Appeal Decision

Appeal Ref: APP/Z4718/W/23/3331820

102 Redwood Drive, Bradley, Huddersfield HD2 1PW

- The appeal is made under section 78 of the Town and Country Planning Act 1990 (as amended) against a refusal to grant planning permission.
 - The appeal is made by Mr Olukayode Olutayo against the decision of Kirklees Metropolitan Council.
 - The application Ref is 2023/62/90936/W.
 - The development proposed is partial demolition of existing dwelling and erection of replacement dwelling.
-

Project:	Job No:
102 THE SQUIRELS REDWOOD DRIVE BRADLEY	2022-010
Title: GARAGE PLANS & ELEVATIONS	
Scale:	Drawn by:
1:100@A3	AP
Date:	Checked by:
03.11.22	-
Drawing No:	Revision No:
2022-010-(20) 005	-

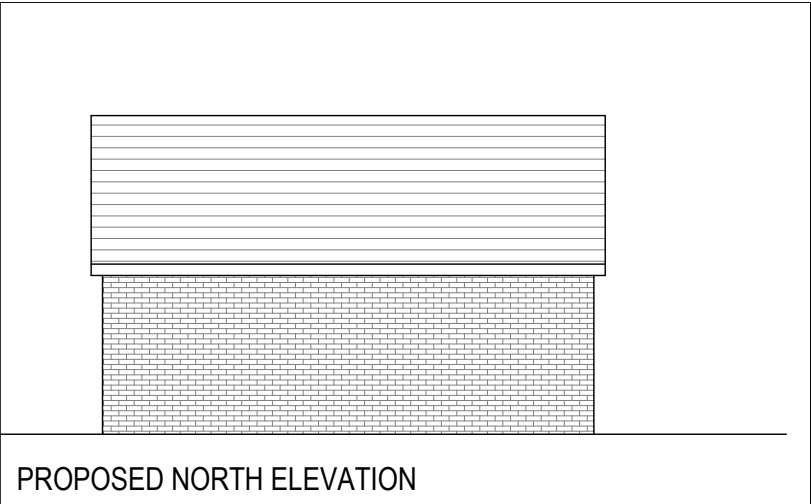
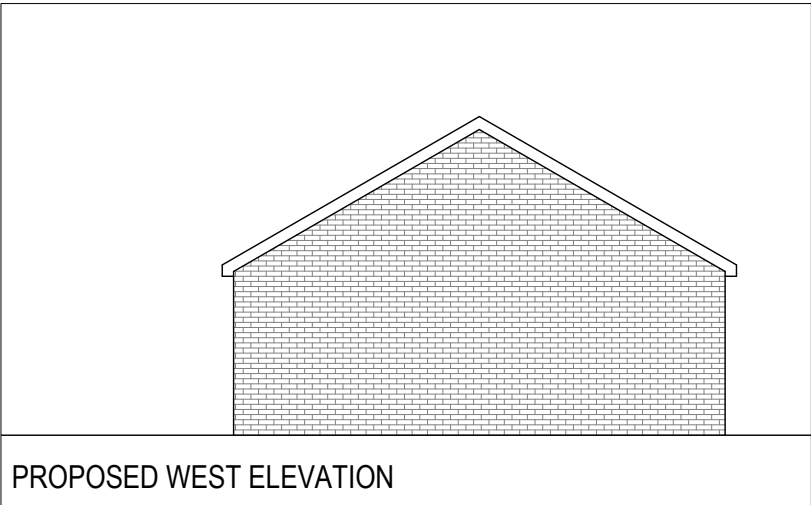
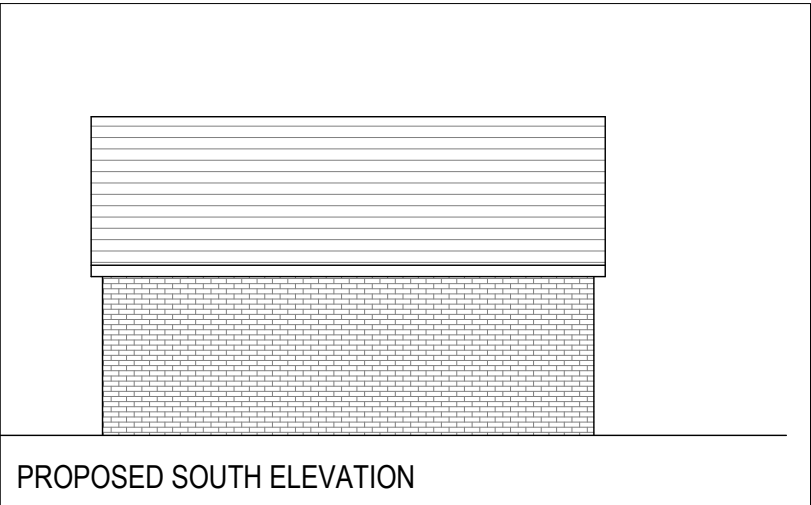
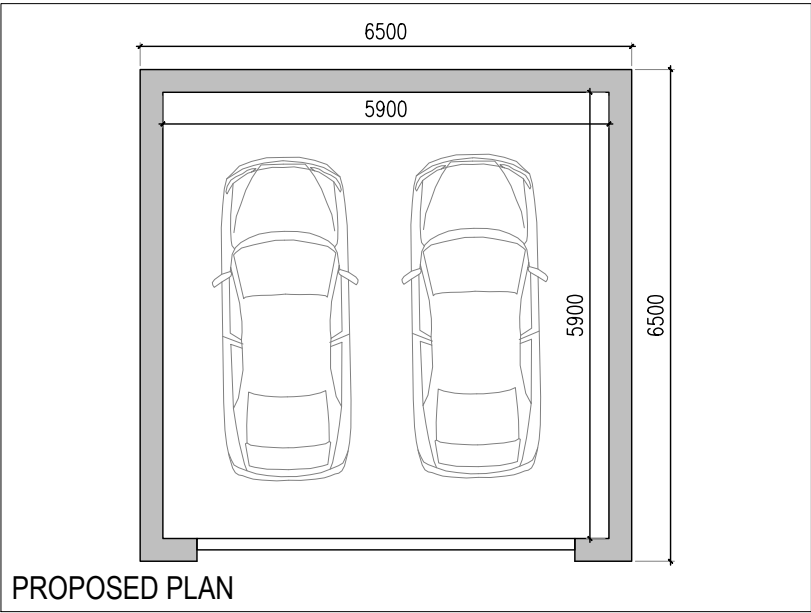
8. Furthermore, the siting of the detached double garage would be a departure from the front building line of the dwellings. It would stand forward of the established line, which would accentuate its prominence as viewed along Redwood Drive. It is acknowledged that the proposed garage would be sited at the head of the cul-de-sac and adjacent to a woodland area, limiting its impact on long-distance public views. However, its position- combined with the site's elevated location- would make the garage prominent and intrusive in close-range views within Redwood Drive.

10. The siting and scale of the garage would fail to respect the coherence of the layout with regard to frontage gardens, to the detriment of the spatial character and landscape quality of this plot and indeed, this part of the housing development. The proposed development would result in the loss of the front garden in its entirety, thereby eroding the contribution that the soft landscaping of the front and side garden makes to landscape character. The property frontage would be dominated by the garage and parking provision, resulting in visual harm to the street scene.

PROPOSED NORTH ELEVATION

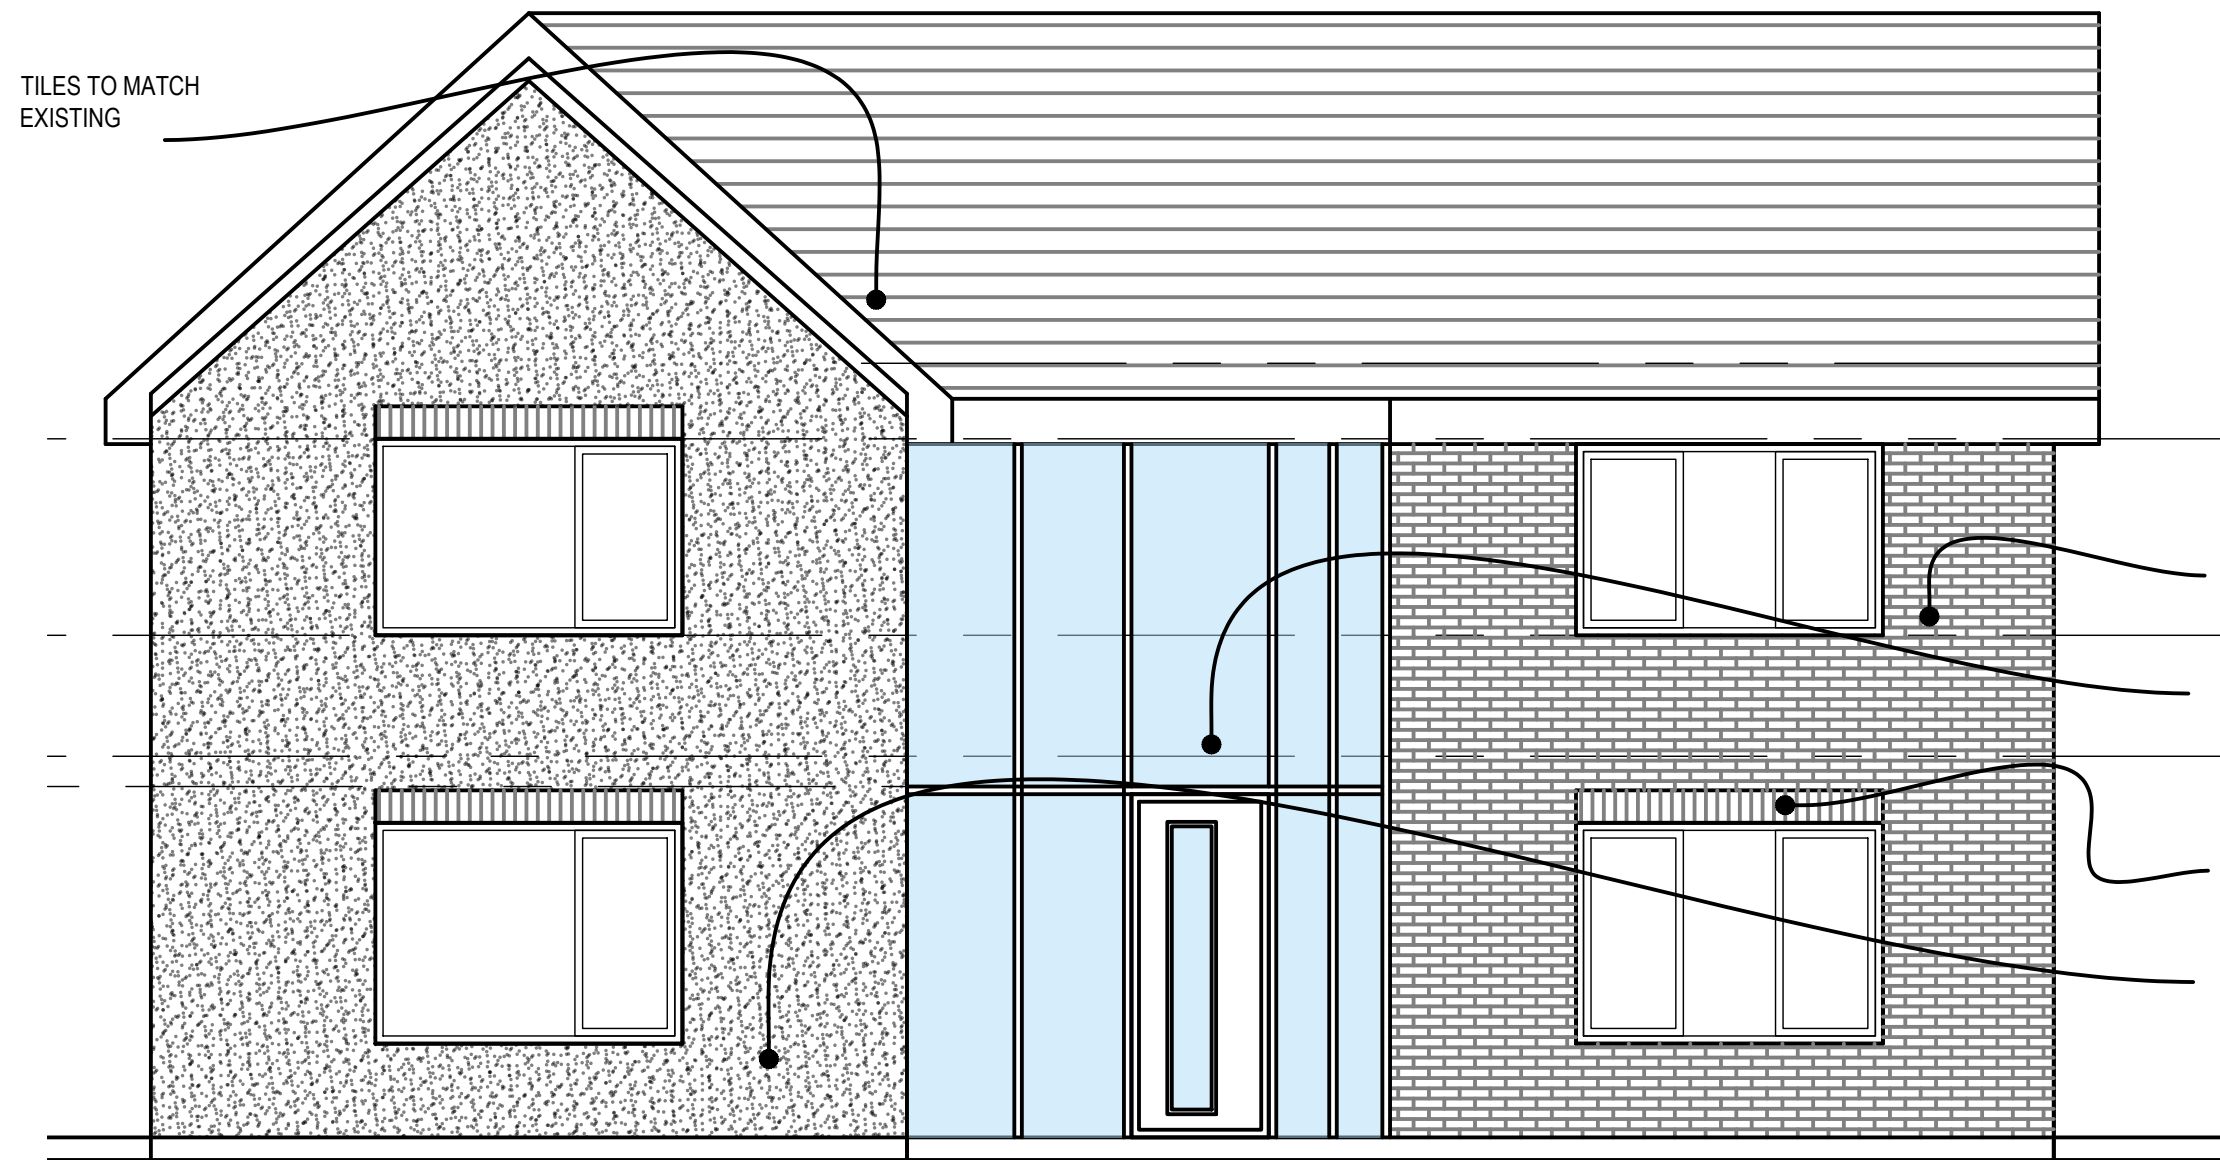
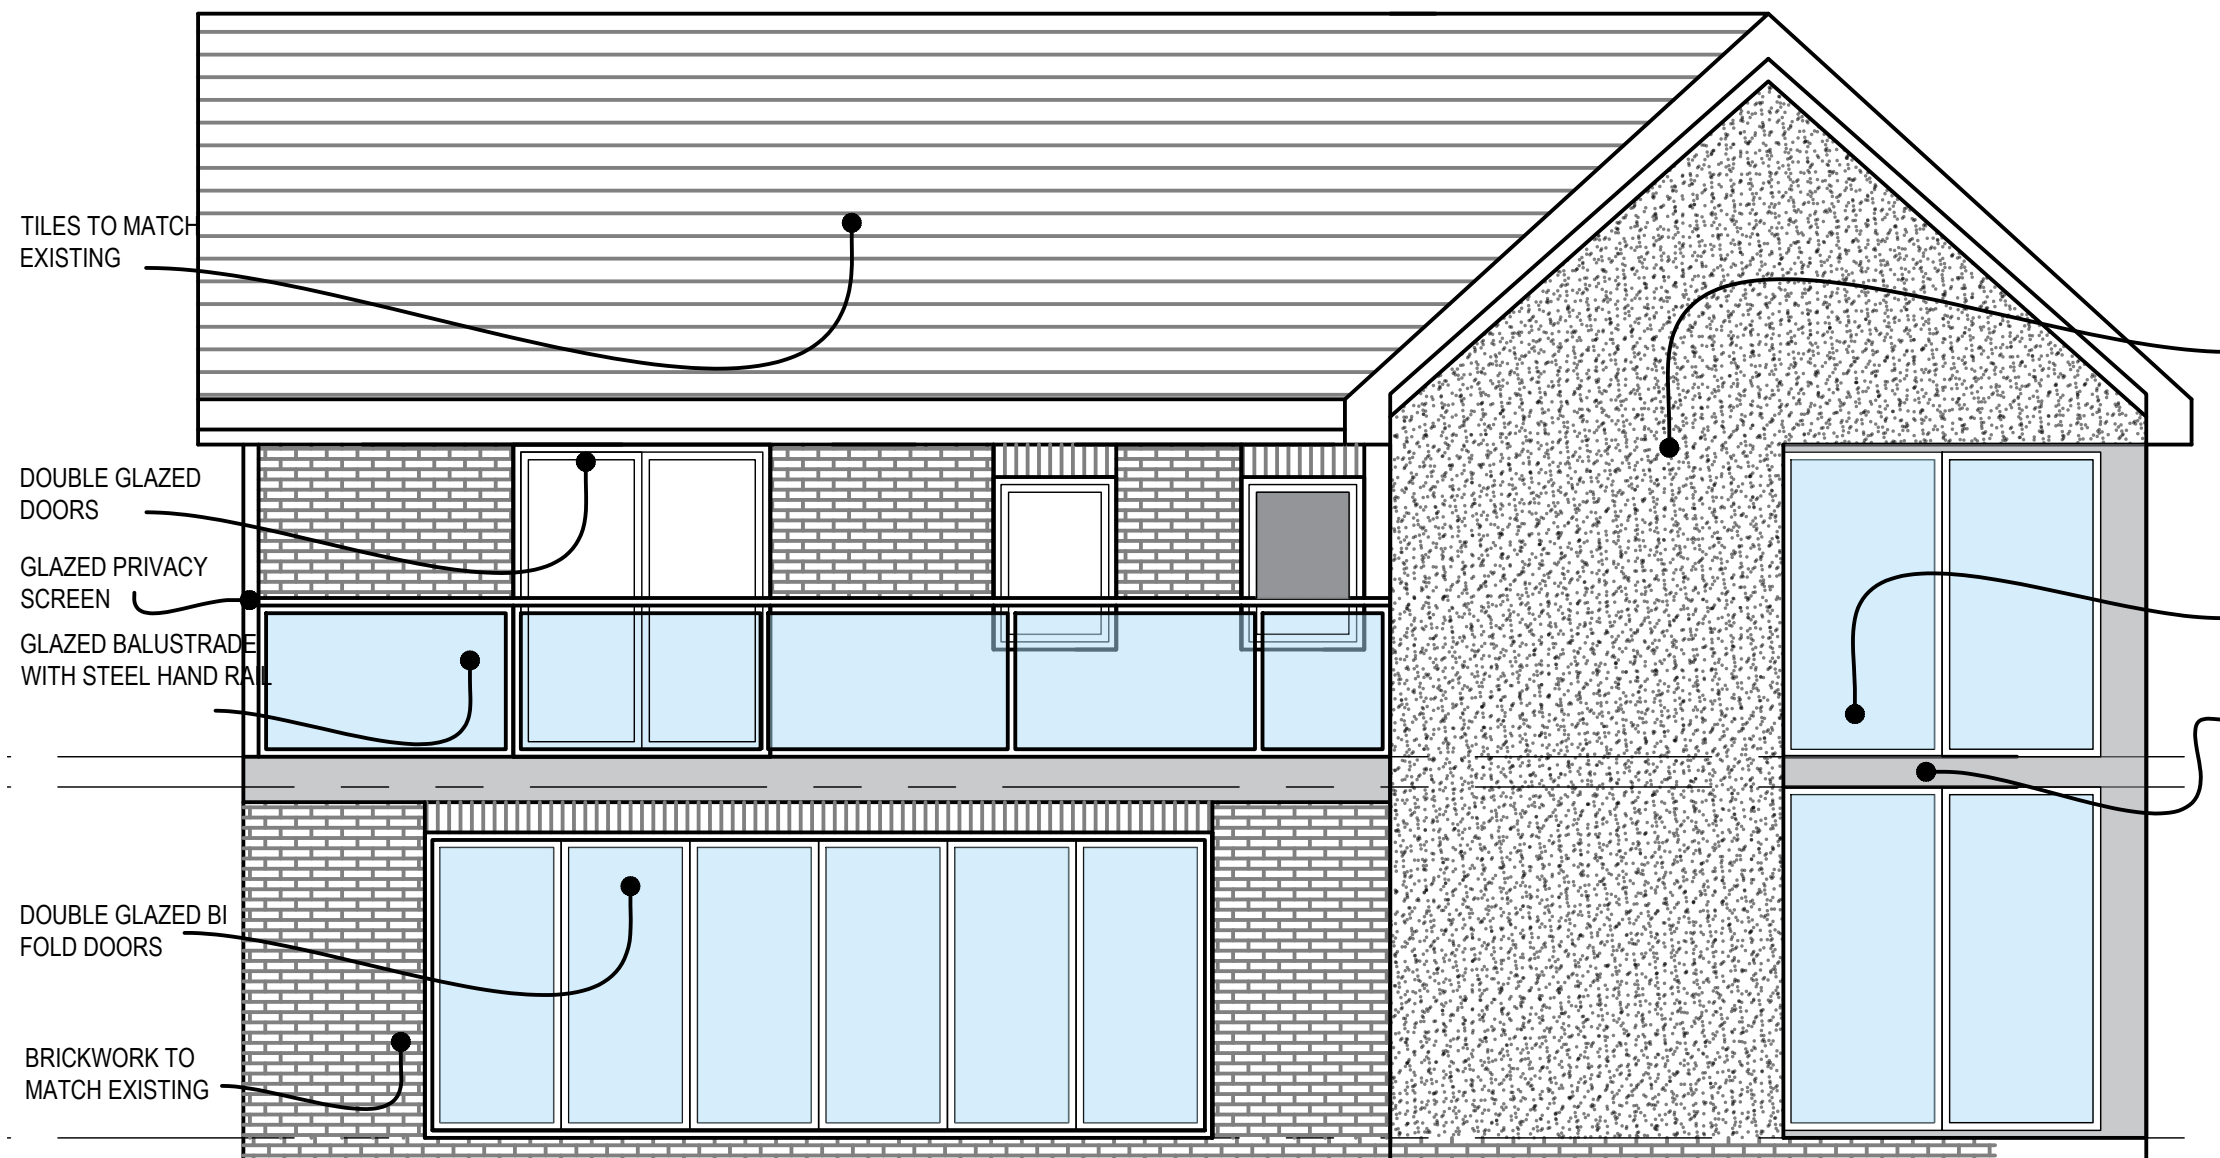
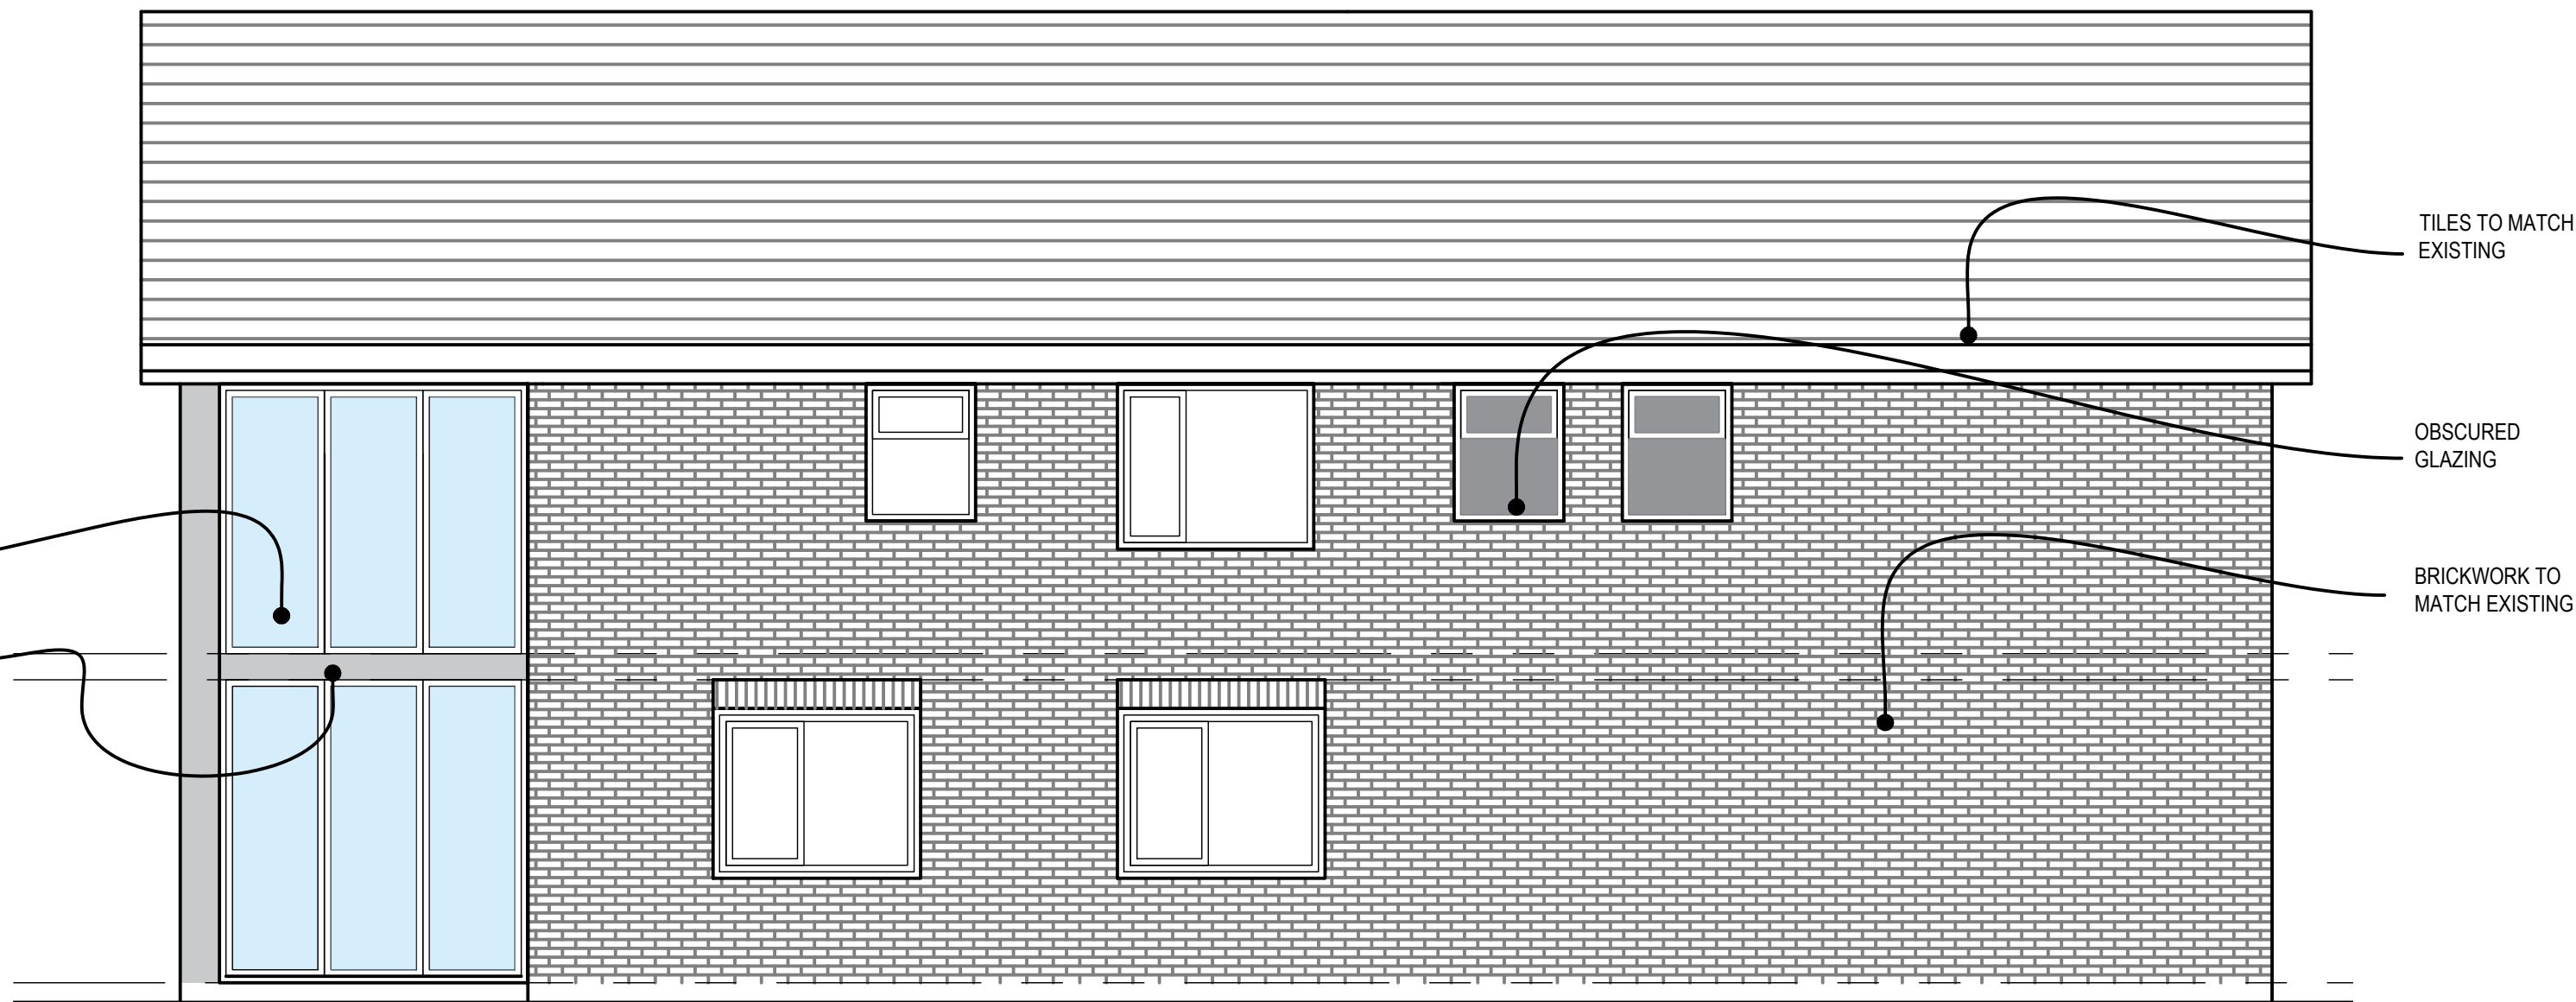
7. The proposed development would substantially increase the depth of the dwelling, resulting in a continuous elongated ridge and eaves line, lacking any articulation or relief. The two-storey front gable projection fails to reflect, or respect, the coherent building line and would appear unduly dominant in the street scene. The visual impact of this projecting gable would be further emphasised by the full height, curved glazed panels of the atrium entrance, which would be visually obtrusive, by reasons of the choice of materials, scale and design.

16. The depth of the rear extension would extend at two storeys in height alongside, and in close proximity to, the shared boundary with 100 Redwood Drive. The overly wide gable presents an expanse of largely blank wall, which would be a solid mass, lacking any articulation. The first-floor level is set back at to accommodate the balcony. This set back is insufficient to mitigate the overbearing effect of the development. Notwithstanding the set back or the siting and orientation of 100 Redwood Drive, it is reasonable to conclude that the combined effect of height, depth and overall scale of the proposed development and rear projections to the appeal property, would have a visually intrusive and over-enclosing effect. The topography would exacerbate this effect, given that the appeal site is on higher ground compared with 100 Redwood Drive. As such, the proposed development would result in a diminution of outlook to the detriment of the living conditions of neighbouring occupiers at 100 Redwood Drive.

17. The appeal property would be extended to the rear, thereby reducing the separation distance to the rear boundary and to numbers 11 and 15 Brier Hill View beyond. Notwithstanding the dense tree belt along the shared rear boundary, the relative alignment of the properties, or the guidance in the SPD regarding separation distances, the full height glazing panels on the rear gable projection and the balcony would afford occupiers of the appeal site overlooking into the living accommodation and gardens associated with these properties. This would compromise the living conditions of neighbouring occupiers with particular regard to privacy and undermine the purpose of a private garden.

25. The appeal property is located at the edge of the housing estate and adjacent to the existing Priority Employment Area, which is characterised by business and commercial units, access roads and associated car parking. To the north-west of the appeal site is a café, which is operational Monday-Thursday. This is separated from the site by a close-boarded fence and a tree belt. Whilst this use is an existing source of noise and odour, the proposed development would extend the appeal property closer to the site boundary, thereby reducing the separation distance, and the north-west elevation would have additional apertures at ground and first floor.
